**KIRKLEES METROPOLITAN COUNCIL
INVESTMENT & REGENERATION SERVICE**

**DELEGATED DECISION FOR APPLICATION FOR CERTIFICATE OF
LAWFUL DEVELOPMENT**

Reference no.: 2023/CL/91321/W

Description: Certificate of lawfulness for proposed erection of
outbuilding

Drawing
Proposed Site Plan

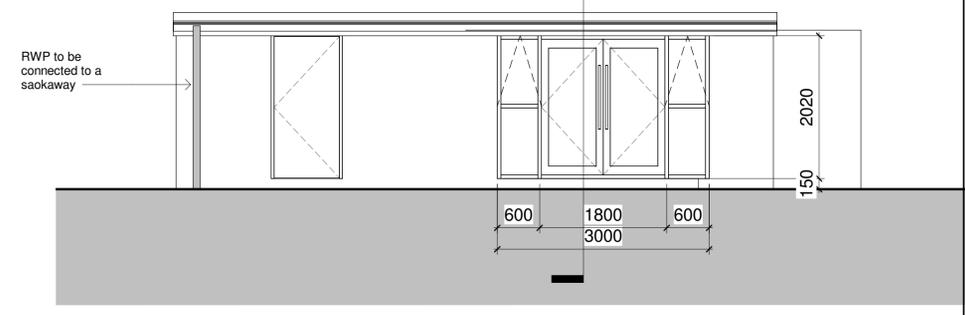
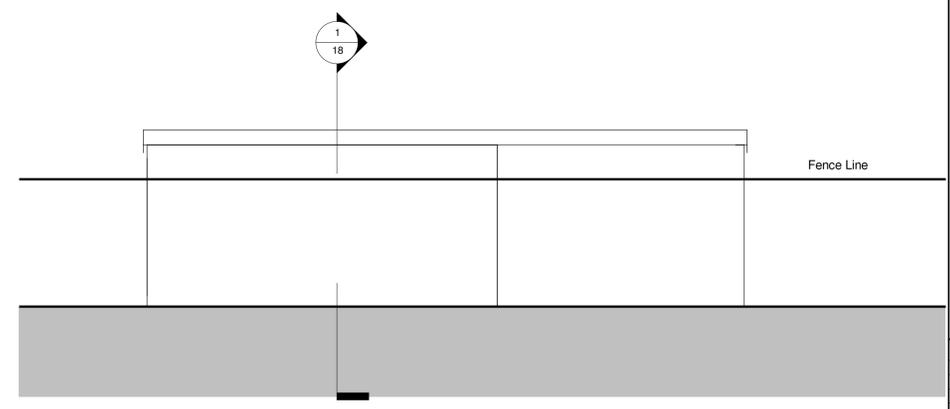
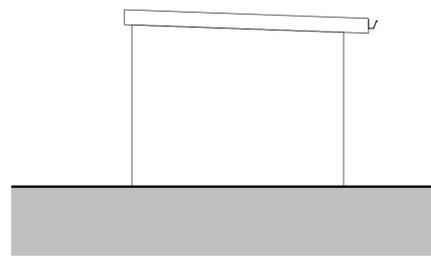
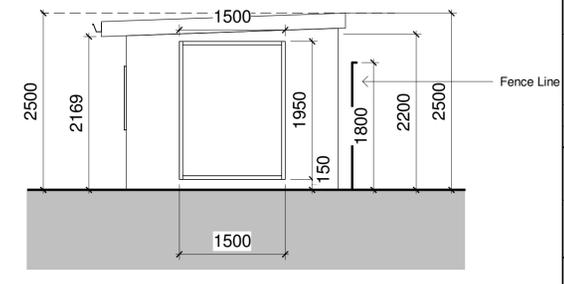
The proposal on submission was unacceptable due to the height of the outbuilding being above 2.5 metres. Officers made contact with the agent to state how the height on submission would not meet guidelines and revised plans would need to be submitted. Amendments were received from the agent showing a reduced height of the outbuilding of 2.5 metres.

Comment: *The proposed maximum height of the outbuilding is 2.5 metres after amendments were secured.*

Comment: *The eaves of the outbuilding would be 2.1 metres.*
